From:	Timothy Lock <tim@gologic.us></tim@gologic.us>
То:	Jean Fraser <jf@portlandmaine.gov></jf@portlandmaine.gov>
Date:	5/14/2014 2:59 PM
Subject:	Re: 97 Cumberland Avenue - level III Site Plan and Subdivision Review

> Together with my colleagues (Urban Designer Caitlin Cameron and Director of Planning Alex Jaegerman) I coordinated a formal design review based on the R6 infil alternative review standards.

> We would appreciate seeing the following so we can finalize the design review:

Basement & Level 1 Plans

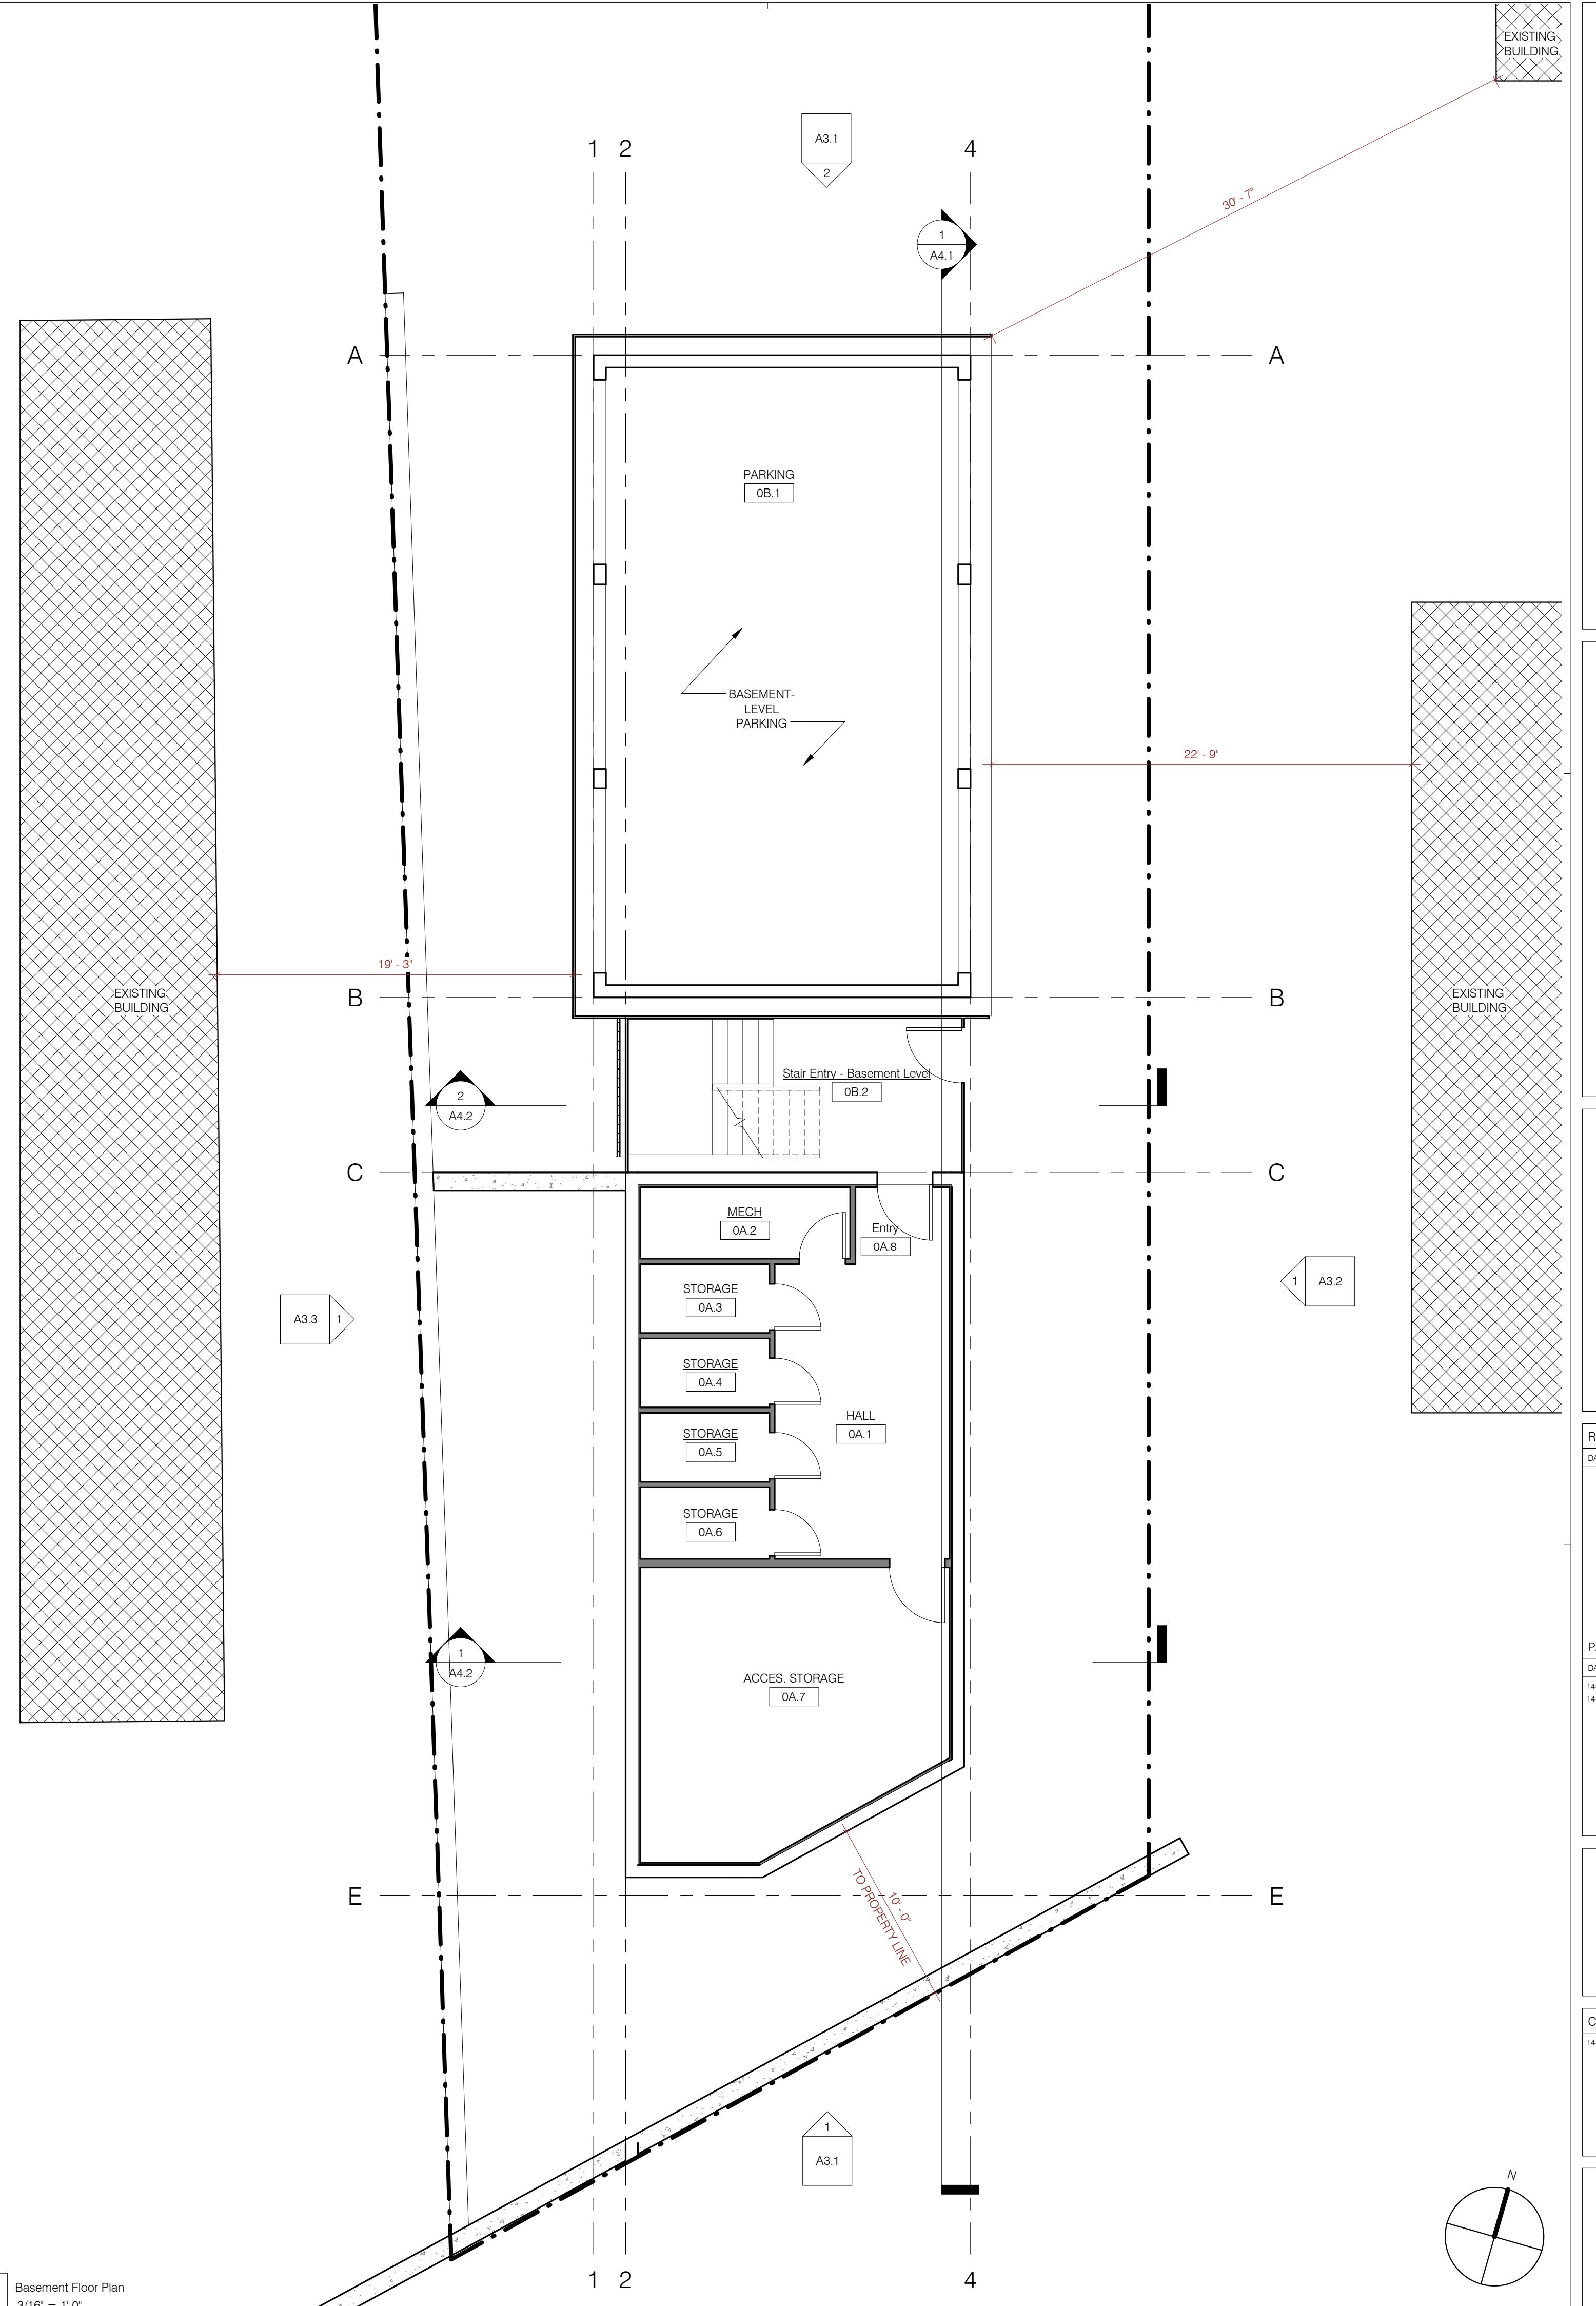
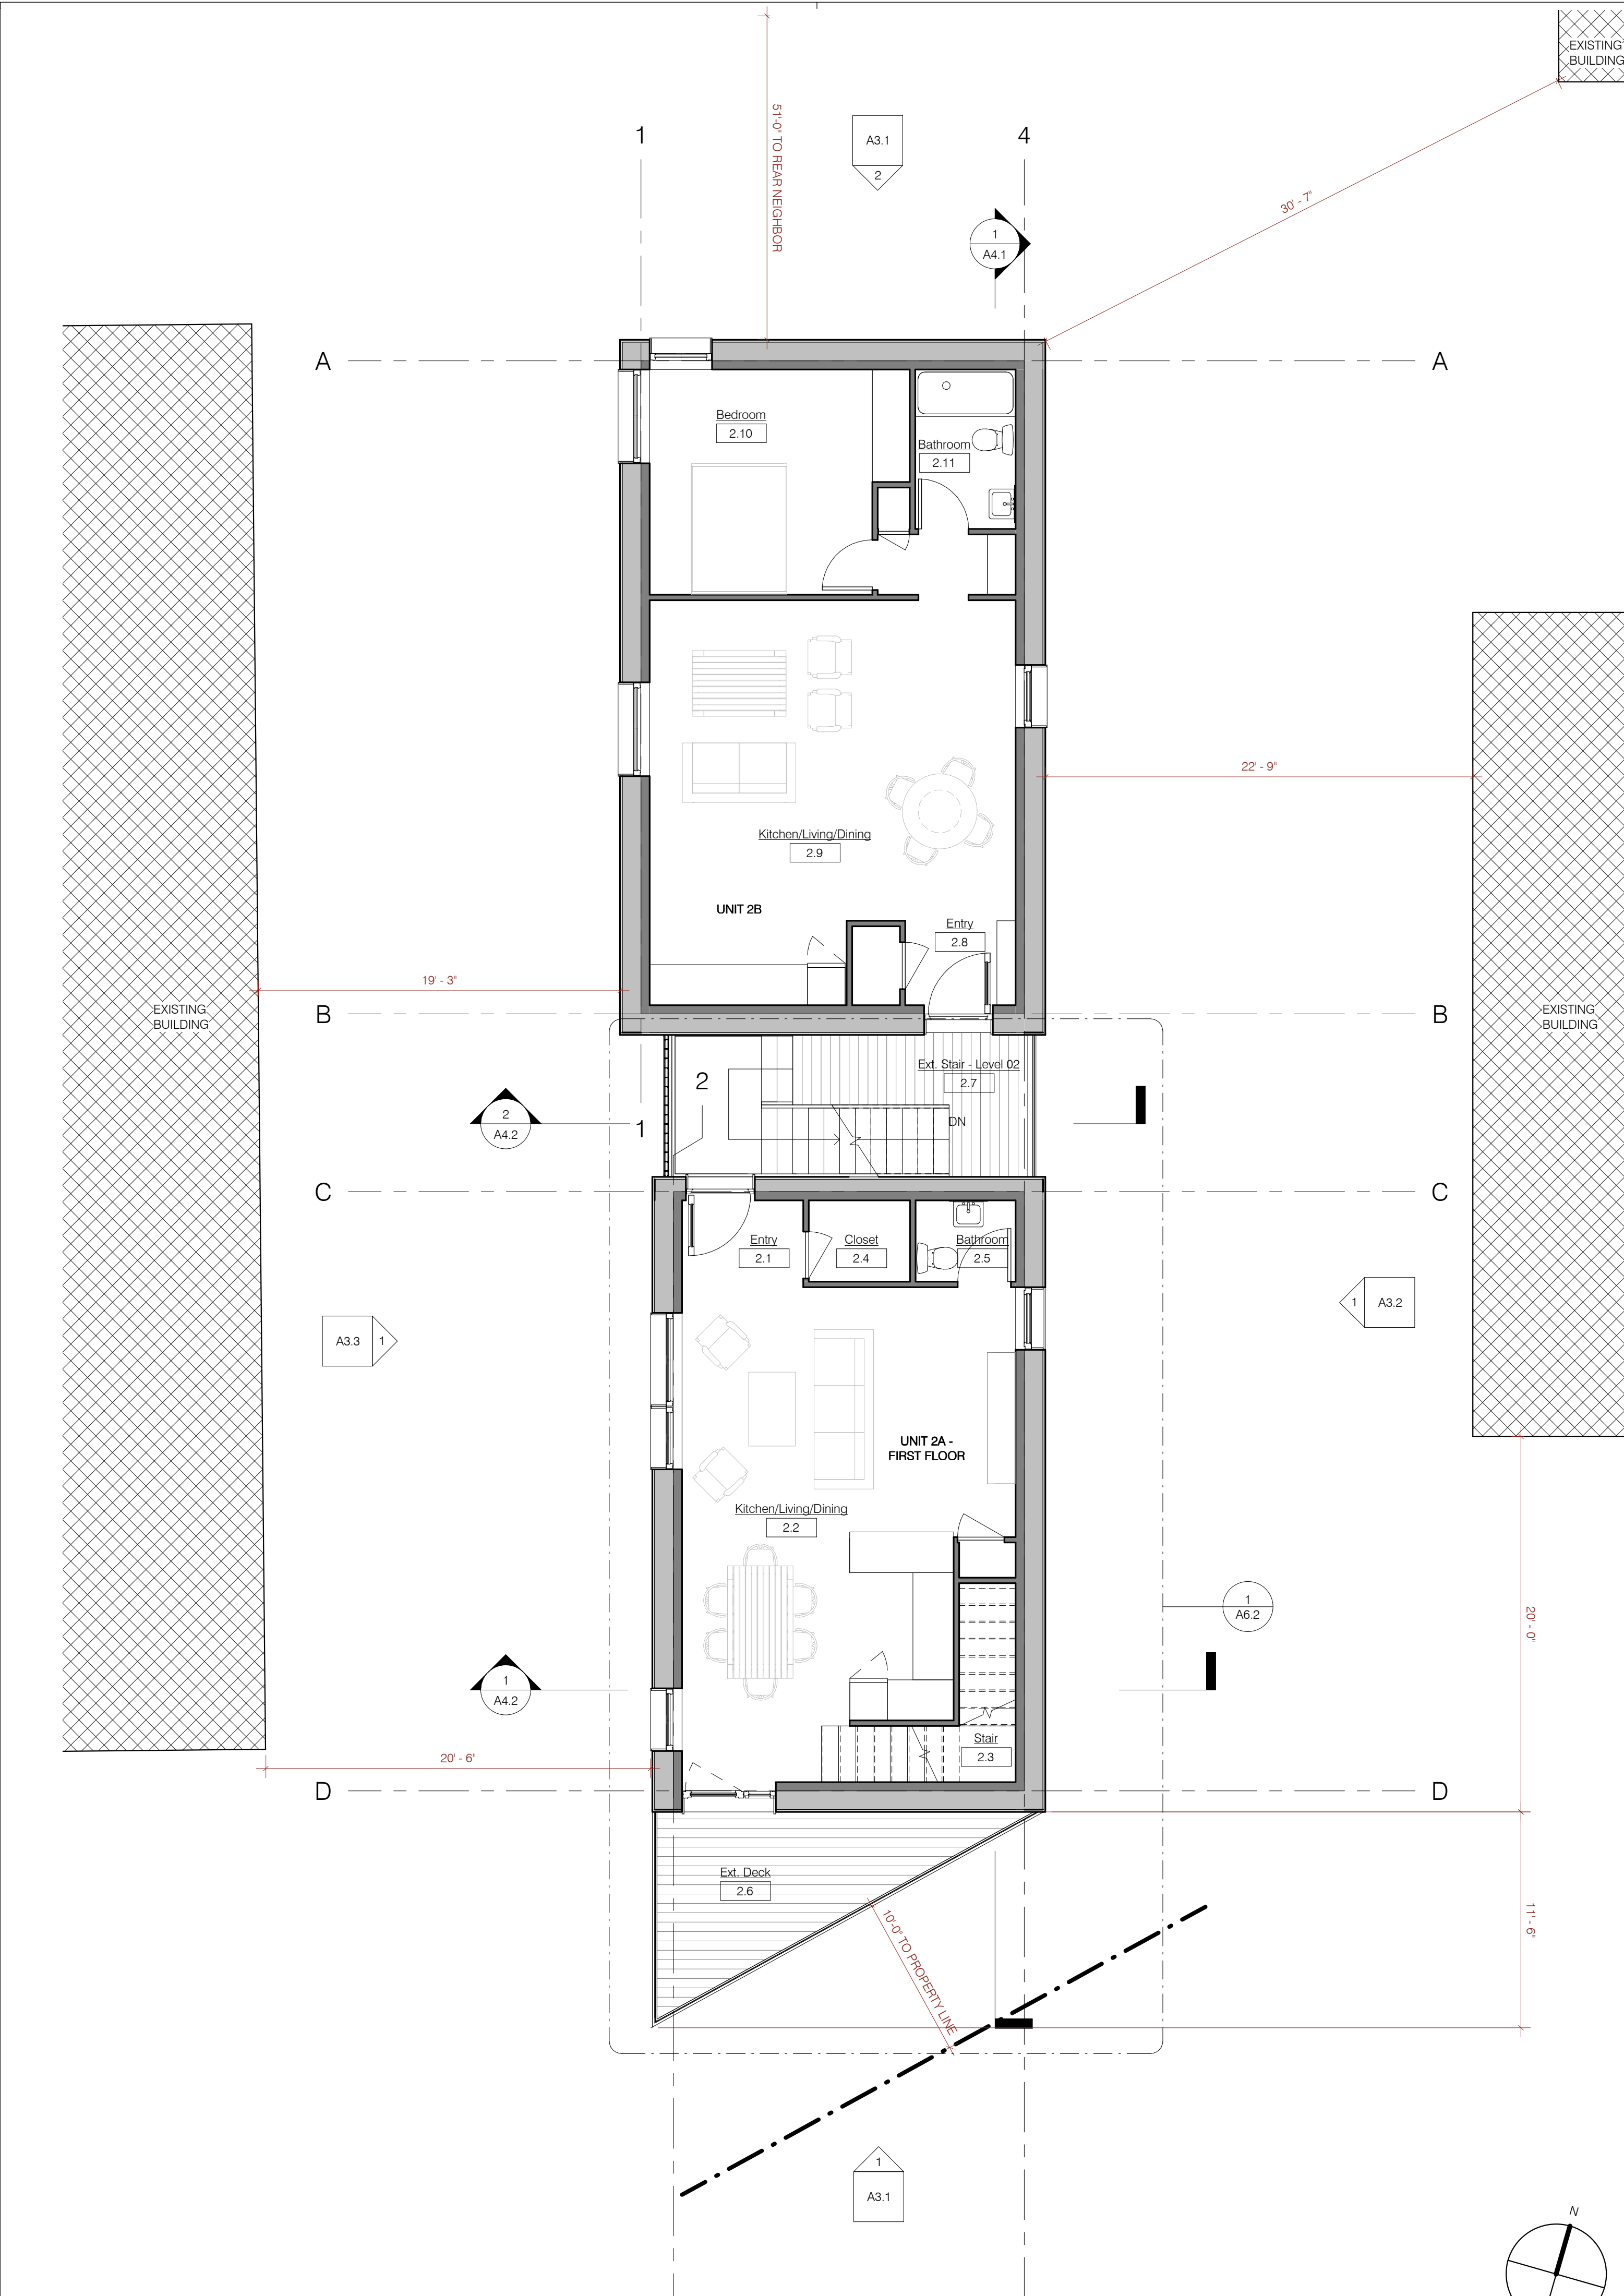
> 1. Floor plans for all buildings and floors;

We will send plans, yes. Floor plans were not indicated as a requirement for Preliminary submittal on the checklist.
